RE: Environmental Assessment Exhibition – Major Project 08_0003 – Construction of 32 dwellings and community title subdivision in two stages at 1206D Pacific Highway Moonee Beach – Lot 211 DP 1044292 & Lot 1 DP 262300

Subject: Major Project 08_0003 Environmental Assessment for 32 lot subdivision, Pacific Highway, Moonee Beach

Re: MP08_0003 - Construction of 32 Dwellings and community title subdivision at 1206D Pacific Highway Moonee Beach – Lot 211 DP 1044292 & Lot 1 DP 262300

Subject: Environmental Assessment Exhibition – 08_0003 - Construction of 32 dwellings and community title subdivision in two stages at 1206D Pacific Highway, Moonee Beach – Lot 211 DP 1044292 & Lot 1 DP 262300

STREETSCAPE VIEW 1

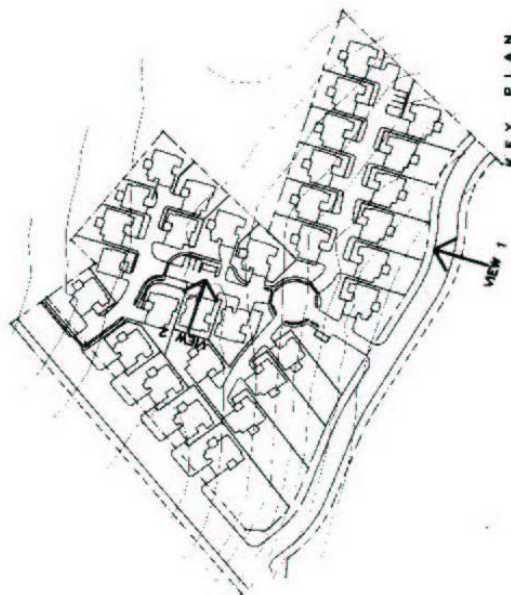
- The streetscape elevation (sheet 32 in attachment 2) is unclear about the lateral extent (distance) of the section, and where it begins and ends.
